Response to Planning application from Hertfordshire County Council (T and CP GDP Order 2015)

District ref: 6/2022/2010/PN24
HCC ref: WH/13691/2022
HCC received: 6 September 2022
Area manager: Matthew Armstrong
Case officer: Steven Knight

EAST SHOWROOM HATFIELD BUSINESS PARK HATFIELD AL10 9WN

Prior Approval for installation of 114kW solar PV system comprising of 300 x 380w Canadian Solar modules.

Proposed (DWG 3)

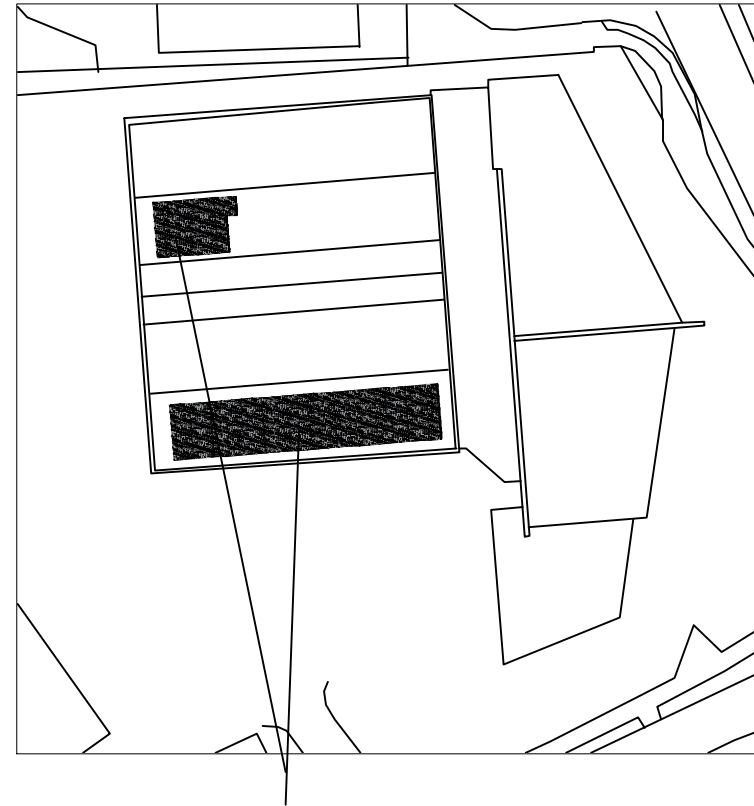
From most parts of the highway the panels will be hidden behind other buildings. Where this isn't the case, they will be in the peripheral vision of drivers and not directly in their line of site. However, given the height and shallow pitch of the roof, it does not appear that the panels be visible from the highway at all.

The highway authority does not wish to restrict the approval of this application as the proposals will have no significant impact on the highway.
